To: All Staff
From: Environmental Health
Date: December 30, 2025
Subject: AU-25-00010 Thompson

for adding a ADU
15x56 - 2 BR.
MANUFACTURED HOME

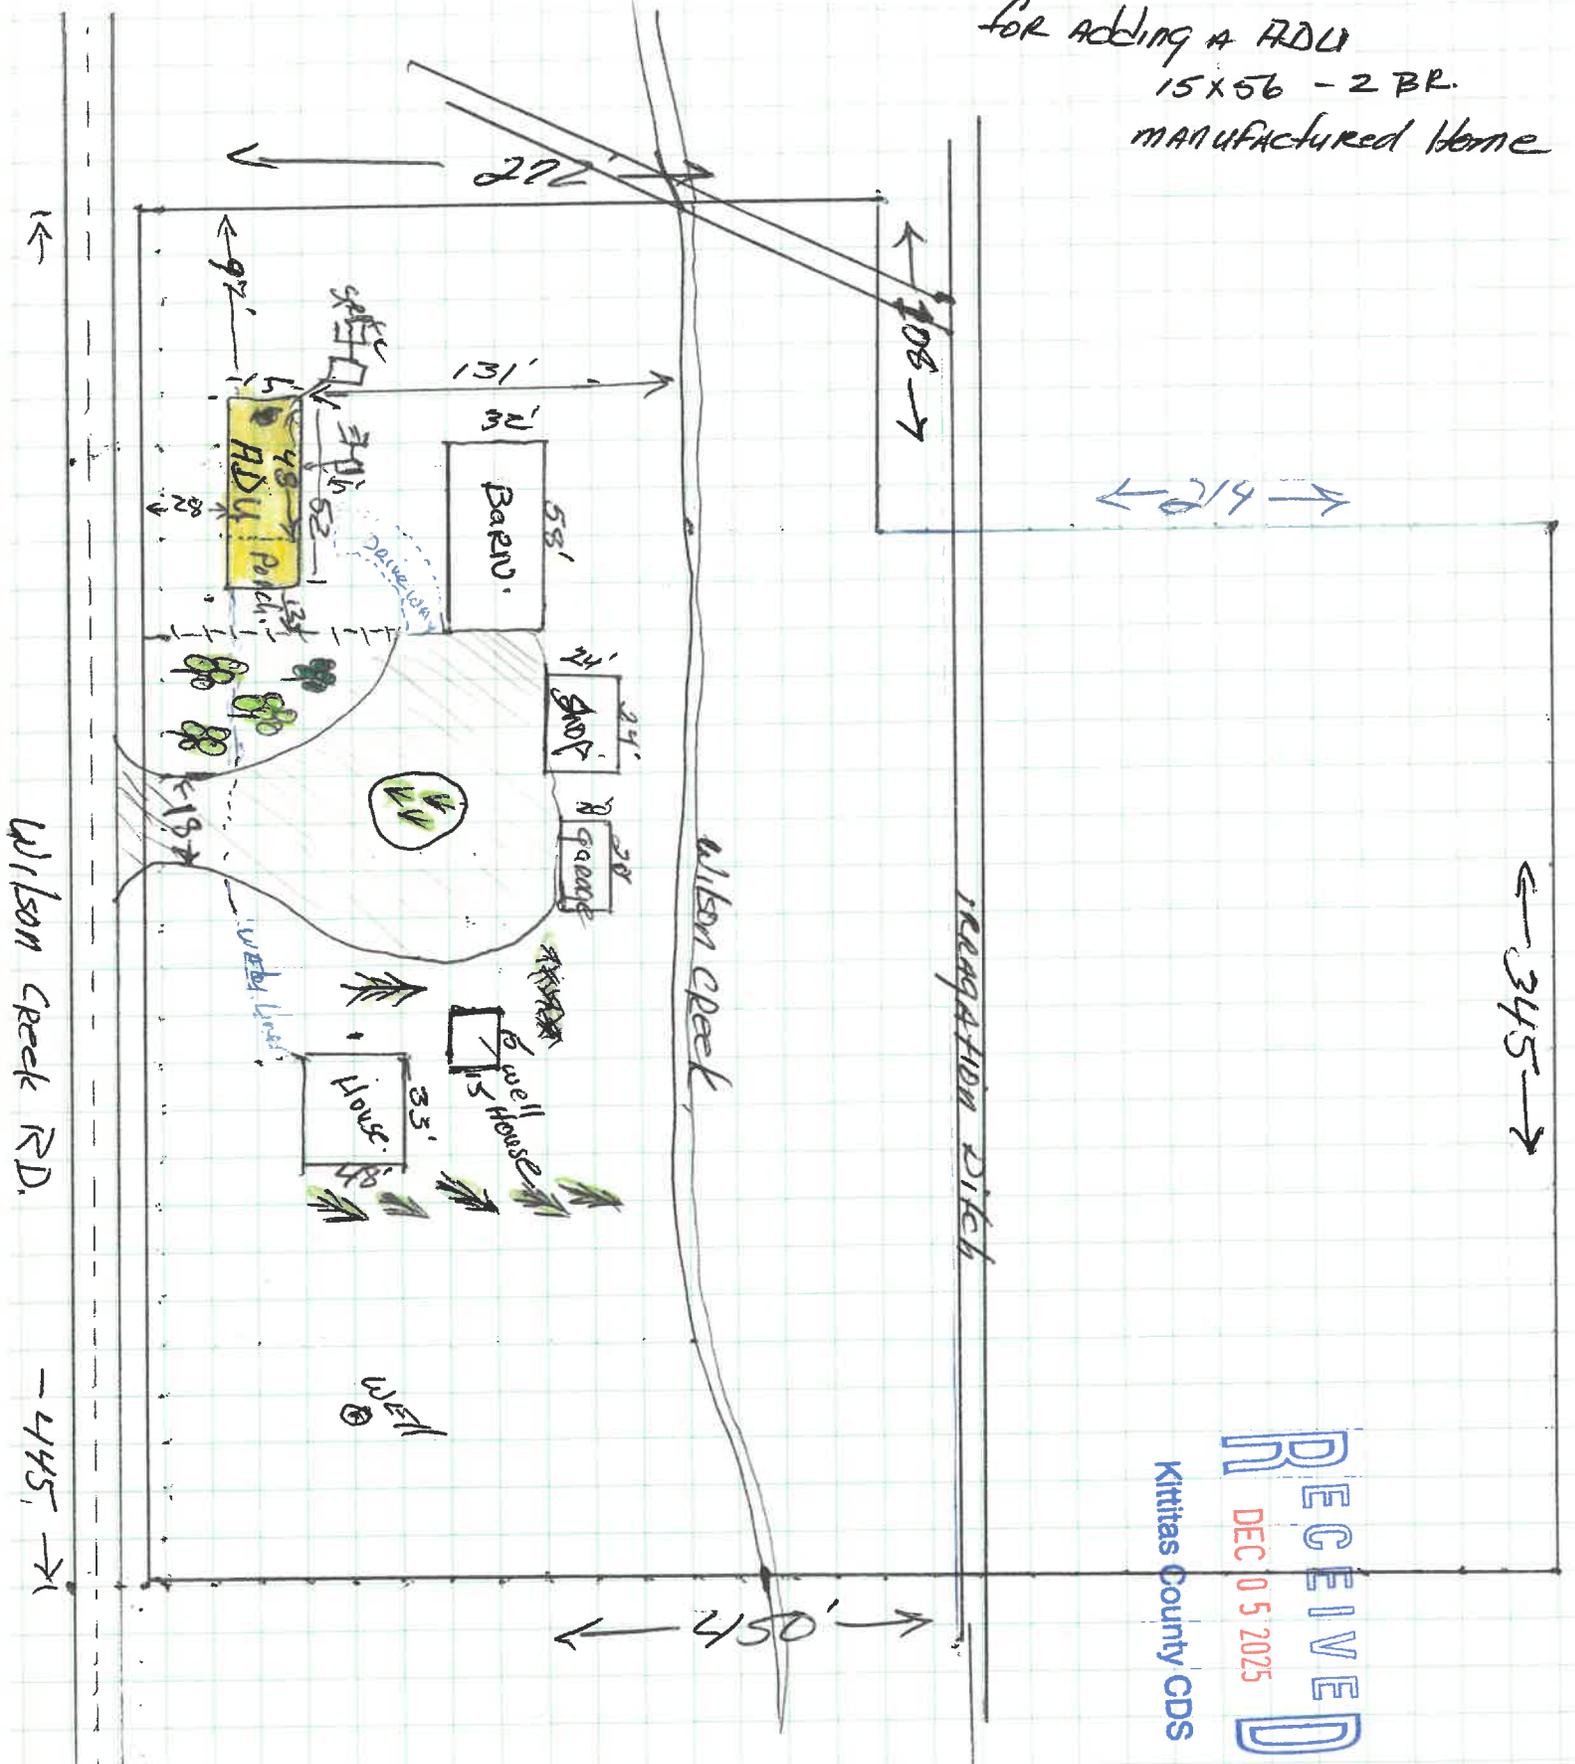
Drinking Water	<ul style="list-style-type: none">• No comment.
Wastewater	<ul style="list-style-type: none">• Site evaluation and septic installation permit approval will be required for ADU connection to current septic system or installation of separate individual septic system.
